Reference No:	2025/65/90113/E
Site Address:	Providence Place, Bradford Road, Cleckheaton, BD19 3PN
Description:	Listed Building Consent for internal and external alterations
Recommending Officer:	Edward Cheseldine

DECISION – GRANT LISTED BUILDING CONSENT

2025/90113 - Providence Place, Bradford Road, Cleckheaton, BD19 3PN

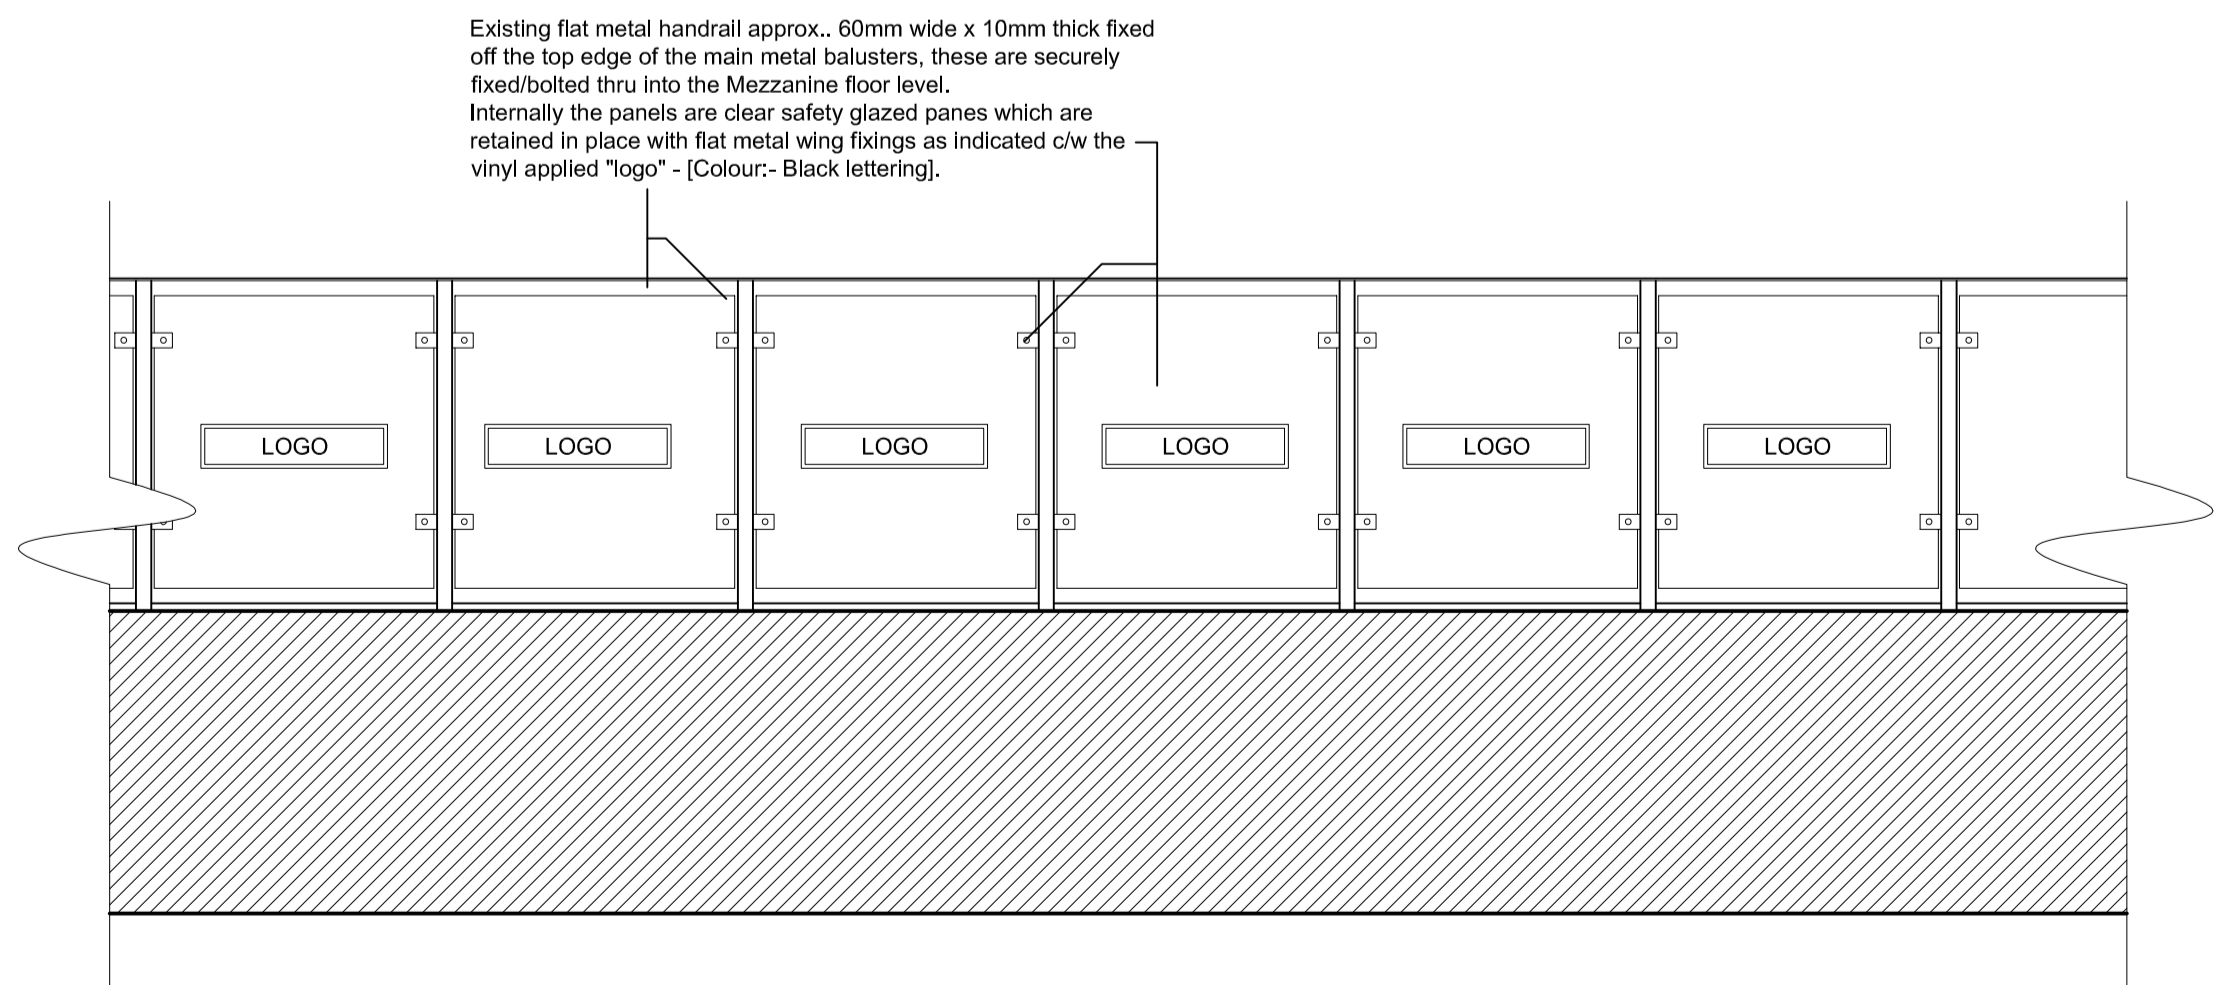
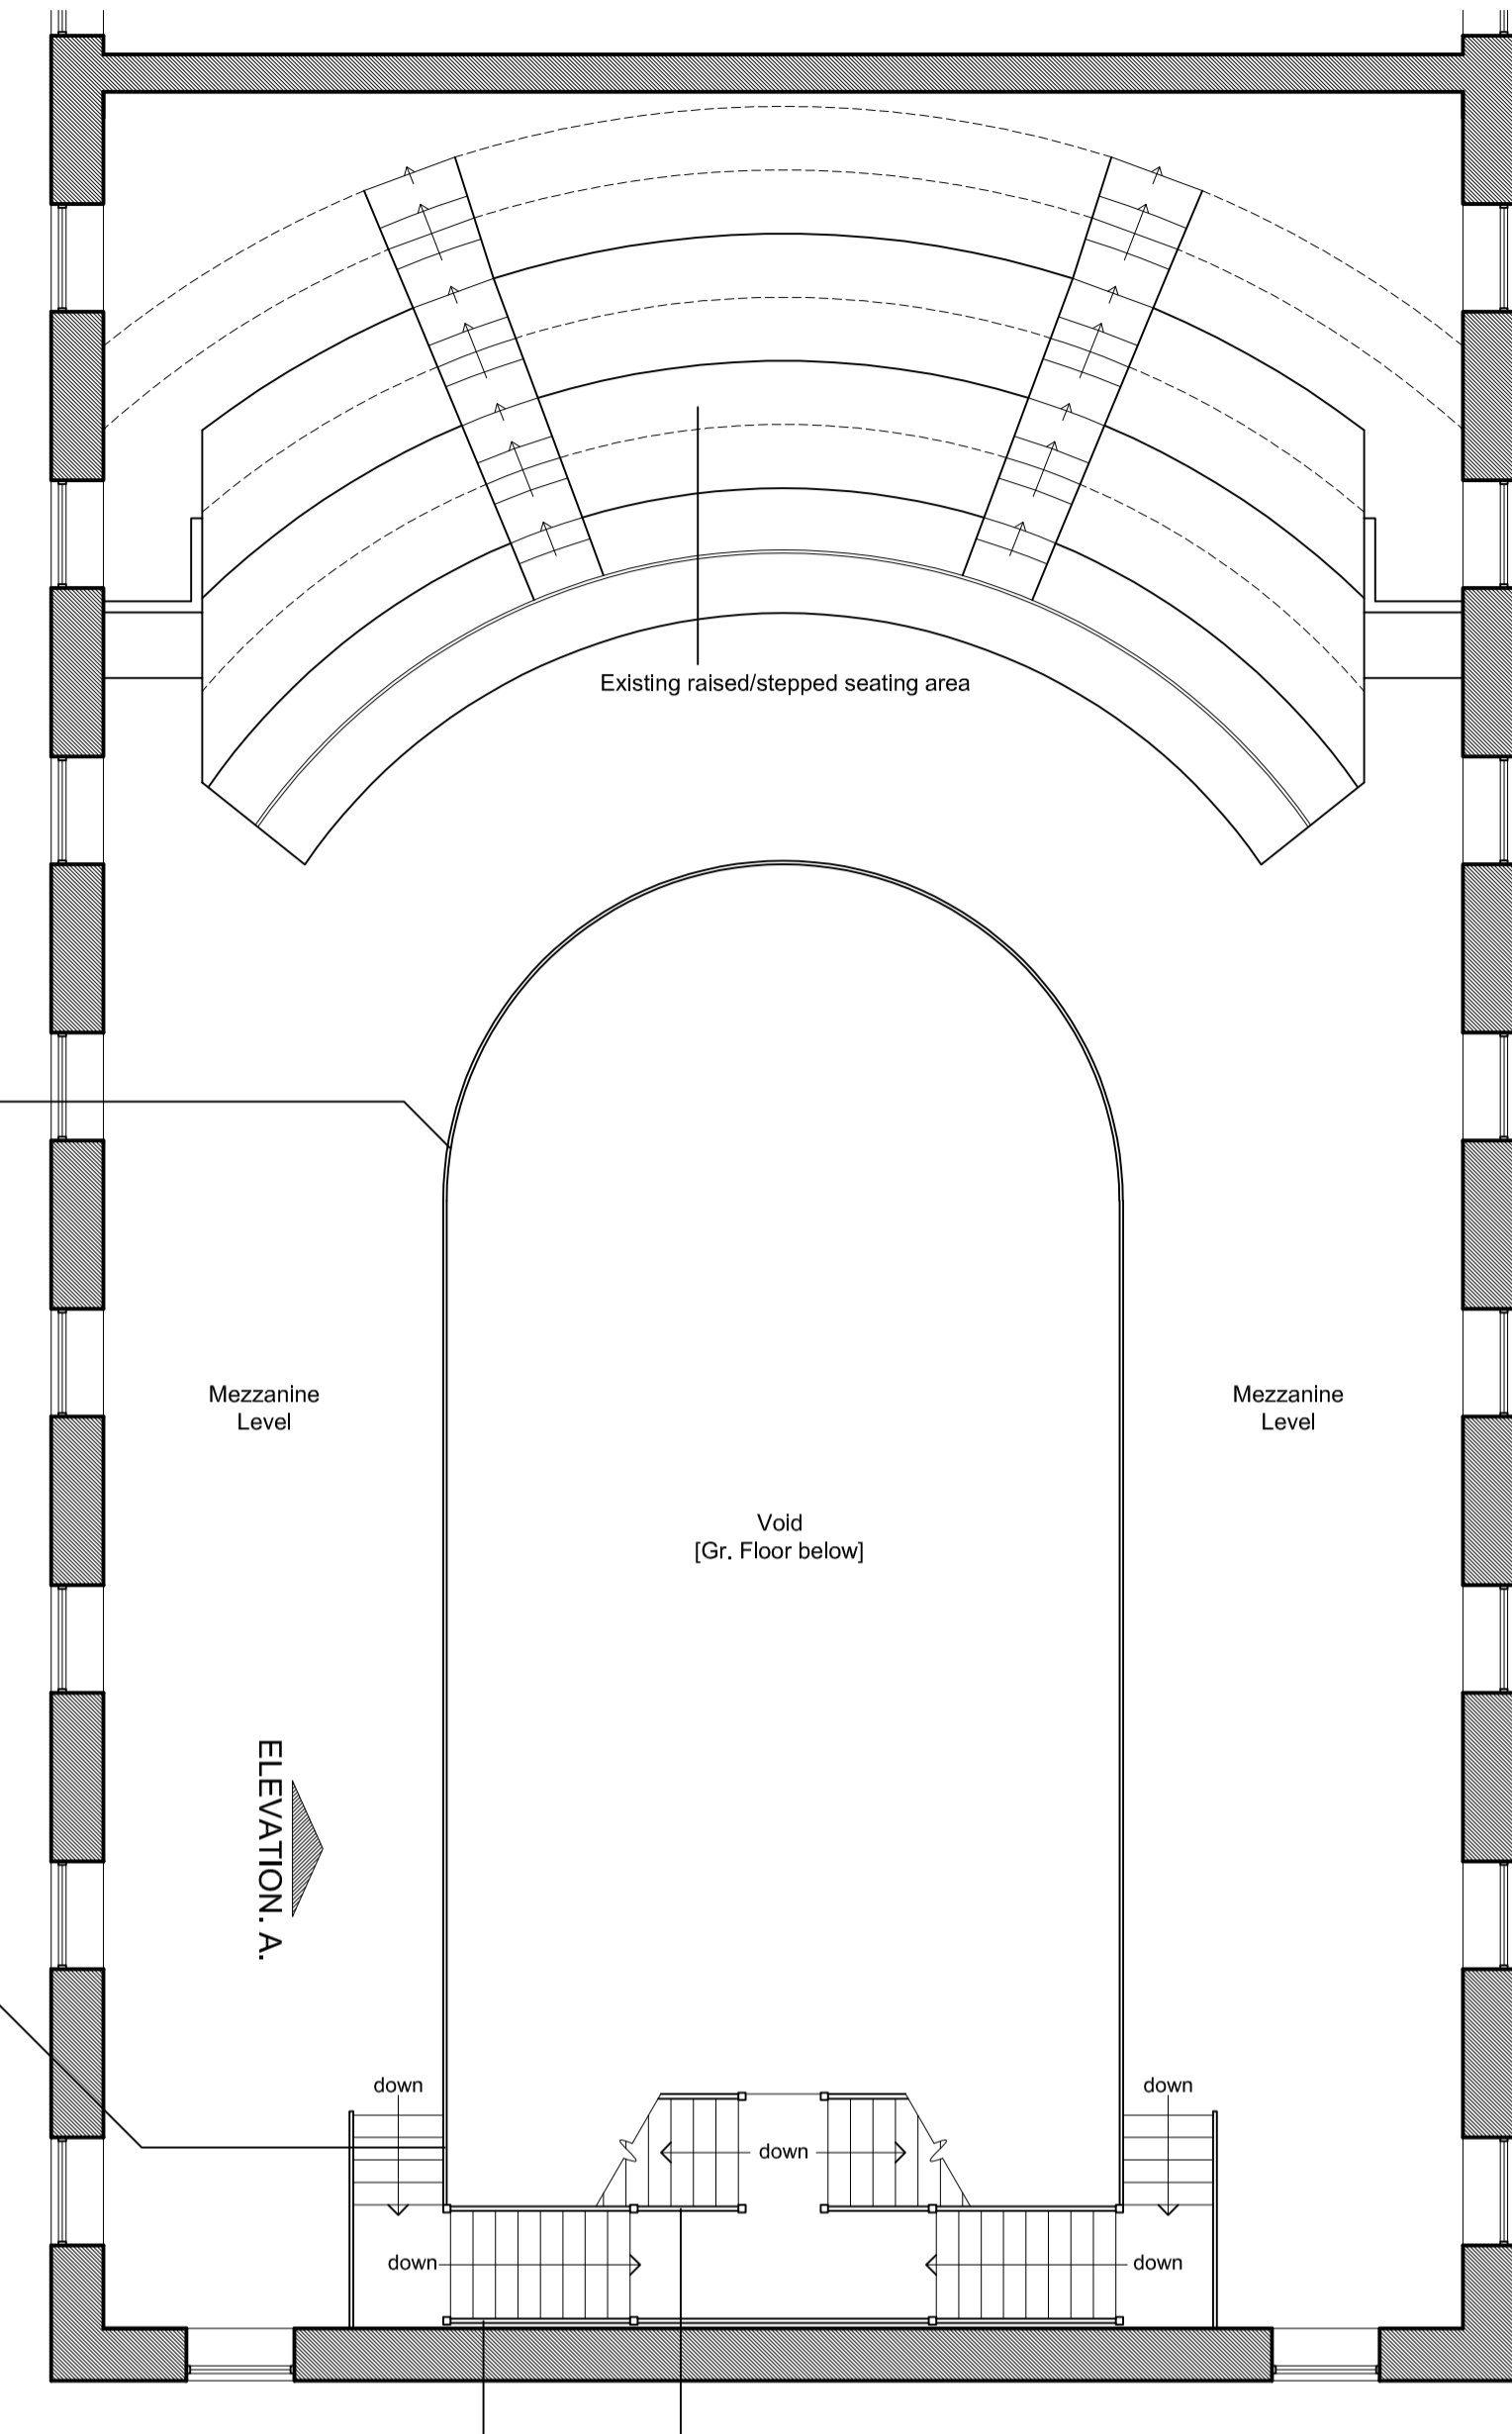
- Change of details of internal decorative balustrade as plans did not accord with materials on site.

Existing balustrades are glazed panels with metal handrails. Replacements are appropriate for the decorative hall, being iron with a period design. Finished in a black gloss. The panels will be fixed by new bars. Existing handrail will be reused. The alteration is appropriate to compliment the internal furnishings and details.
